My Ref: 2023/ENQ/00158  
Your Ref:  
Date: 1<sup>st</sup> June 2023  
Enquiries to: Matthew Marsden  
Direct Dial:  
E-Mail: [developmentmanagement@barnsley.gov.uk](mailto:developmentmanagement@barnsley.gov.uk)

**Description:** Non material amendment of application 2018/1269 (Erection of 2.4m high perimeter security fencing and entrance gates and formation of new external loading door and windows on the existing building) to form two separate smaller window openings on the first floor, based on the same size and style of the unit's existing windows

**Address:** Unit 1, Shortwood Court, Hoyland, Barnsley, S74 9LH

Proposed south elevation 1:200

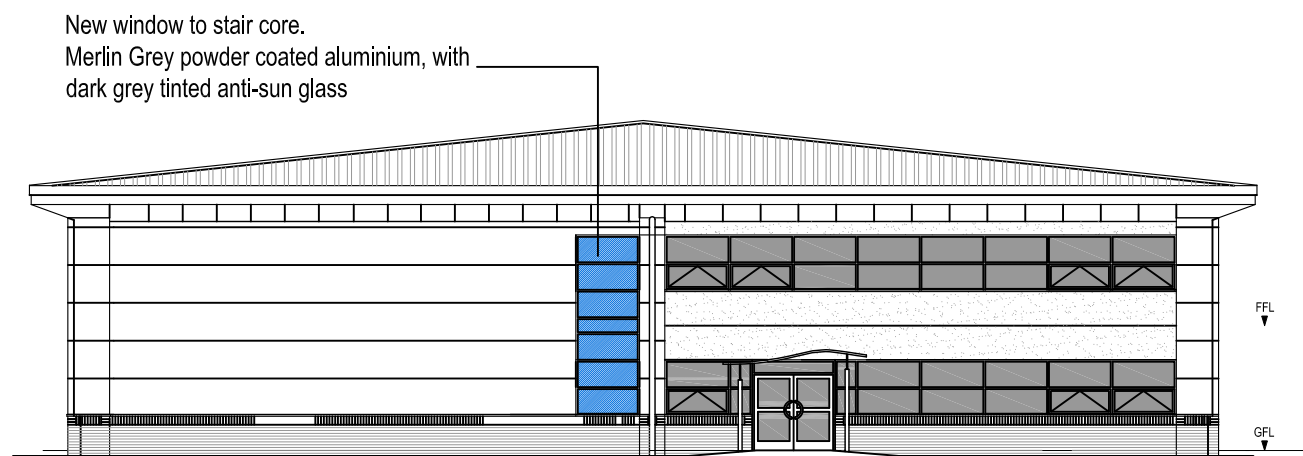
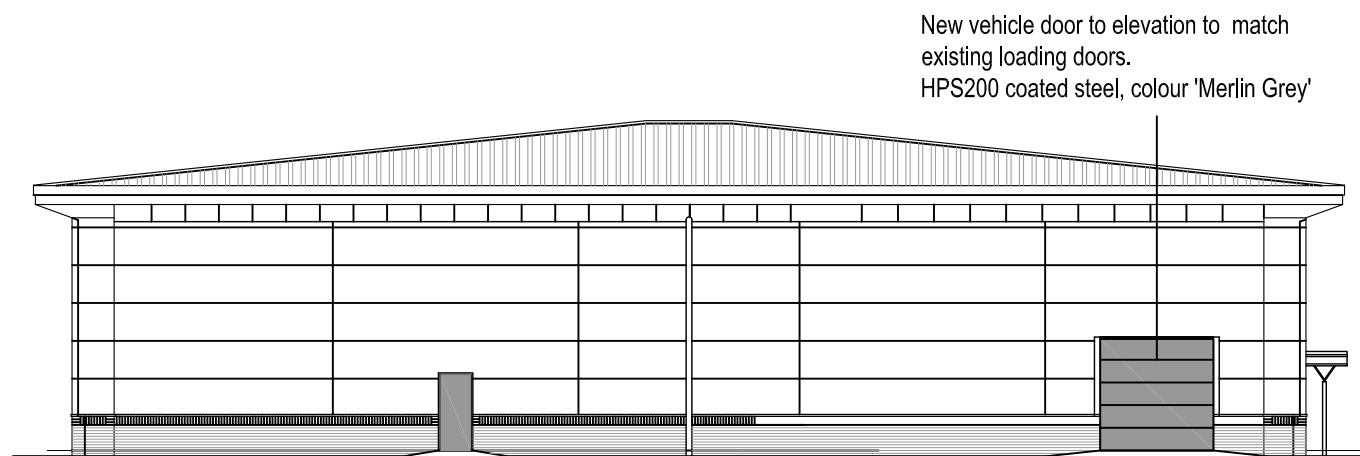
- An alteration to the proposed windows to form two separate smaller window openings on the first floor, based on the same size and style of the unit's existing windows instead of the originally proposed column of windows on the south elevation of the unit.

The details submitted on plans Proposed South and West Elevations received on 24<sup>th</sup> April 2023 are acceptable in that the amendments would not unreasonably impact on the amenity of surrounding residents or the character of the area. As a result, the proposed non-material amendment is hereby approved. This decision letter only relates to the non-material amendment. It is not a reissue of the original decision notice for application 2018/1269 which still stands. The two documents should be read in conjunction. If you require any further information, please contact me.
